From: Brown, Sophie [REDACTED]
Sent: 16 July 2024 13:53
To: [REDACTED] Ian Johnson; Venturini, Bruno (Guest)
Cc: Jessica Riches; PlanningSSD
Subject: AL/11/24/OUT - Land East of Westergate - Flood model 2024
Attachments: LIT 17617 - Non-real time Hydraulic model review East_Westergate_ICM.xlsm

NON-REAL TIME HYDRAULIC MODEL REVIEW

Project	Land East of Westergate	Job Number		Required coastal standard (if applicable)	
---------	-------------------------	------------	--	---	--

Figure 4-1 – Location of cross sections for the Lidsey Rife and the Westergate Stream (part 1)

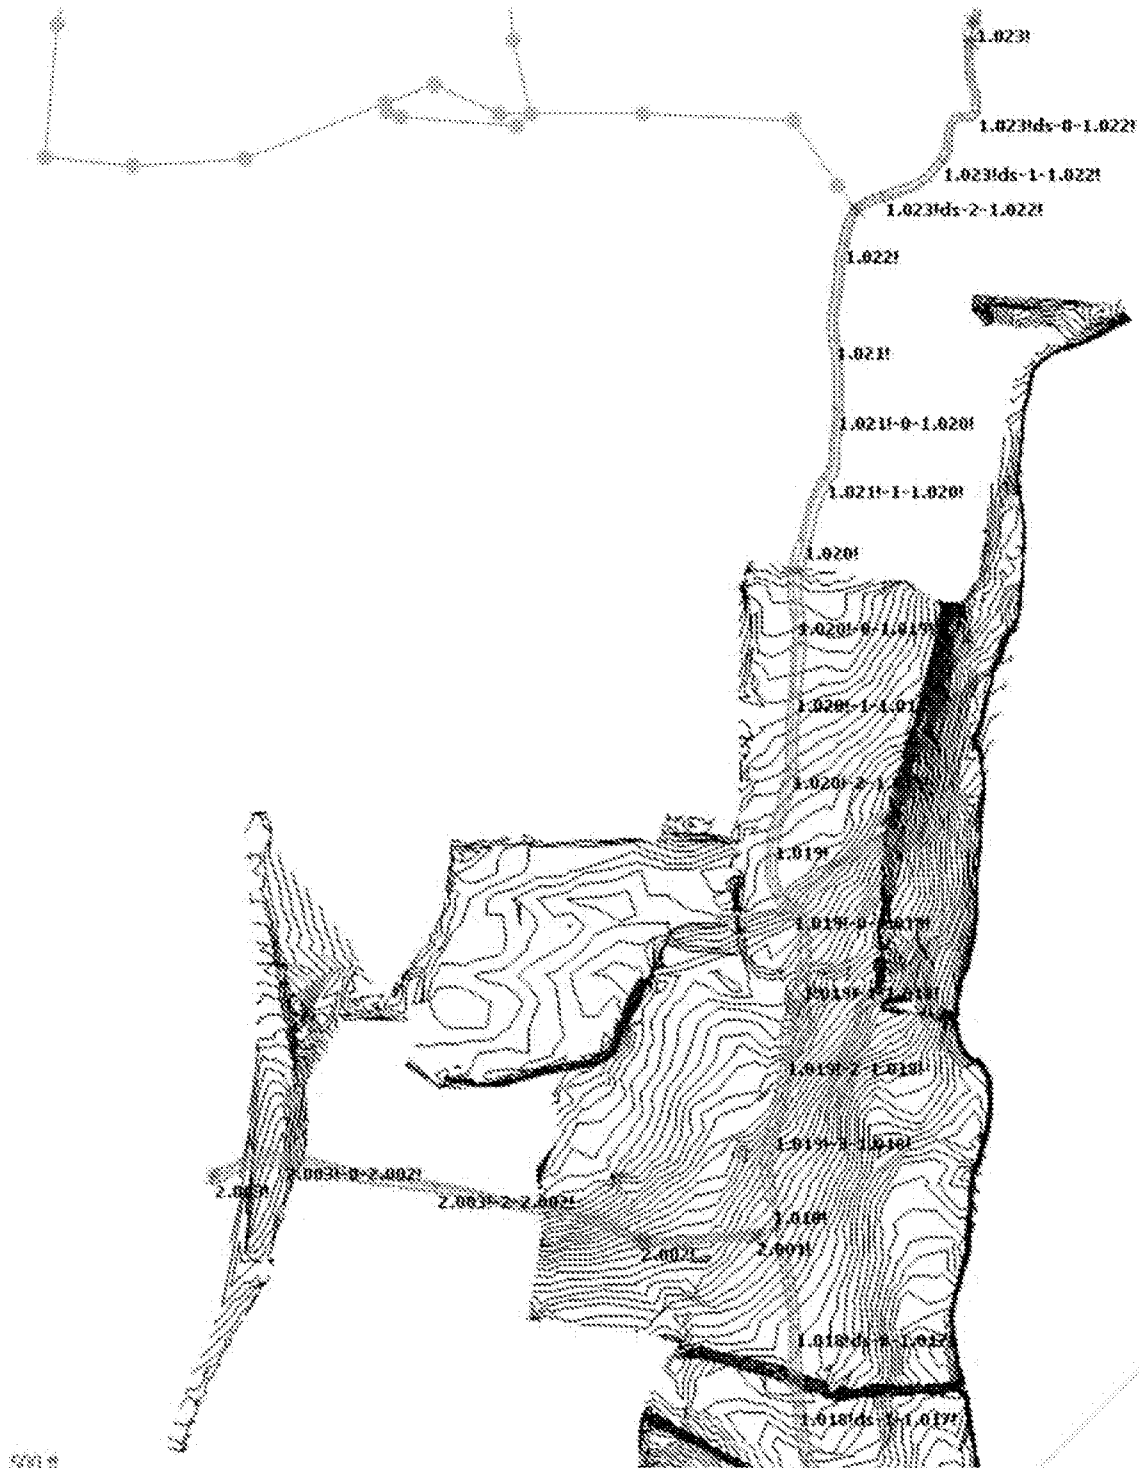
3.2	Have appropriate distances between sections and/or nodes been used (dx)?	Green	As per Fluvial Design Guide, most channels are appropriately spaced (less than 20' channel width), with few exception near the following cross-sections: 1.029 7.048 7.049	Review the fluvial design guide and how it is applicable for ICM models. Add a note in report about cross-section spacing. Review the location of cross-sections such that changes in river width and gradient are captured in addition to acceptable chainage between sections.

3.4	Is the model geo-referenced?	OK	Model is referenced to British National Grid.	no action										
3.5	Do the cross sections and bed profiles look reasonable?	Amber	Most cross sections look reasonable. There are a few where the banks suggest that online storage is present. In this case, a single cross section does not correctly represent this feature. Example cross sections: 5.013 21.006	Review these; consider the use of a storage area which could better represent the attenuation.

3.6	Chainage – compared to surveyed sections	N/A	Survey data not provided as a part of the review.	no action										
3.7	Does conveyance look appropriate?	Green	Conveyance looks mostly appropriate. Conveyance of sections at the river reach downstream of the area of interest shows some irregularities in the conveyance graphs. River reach ID: 1.014kds.	Review conveyance and panel markers to understand irregularities in conveyance plot.
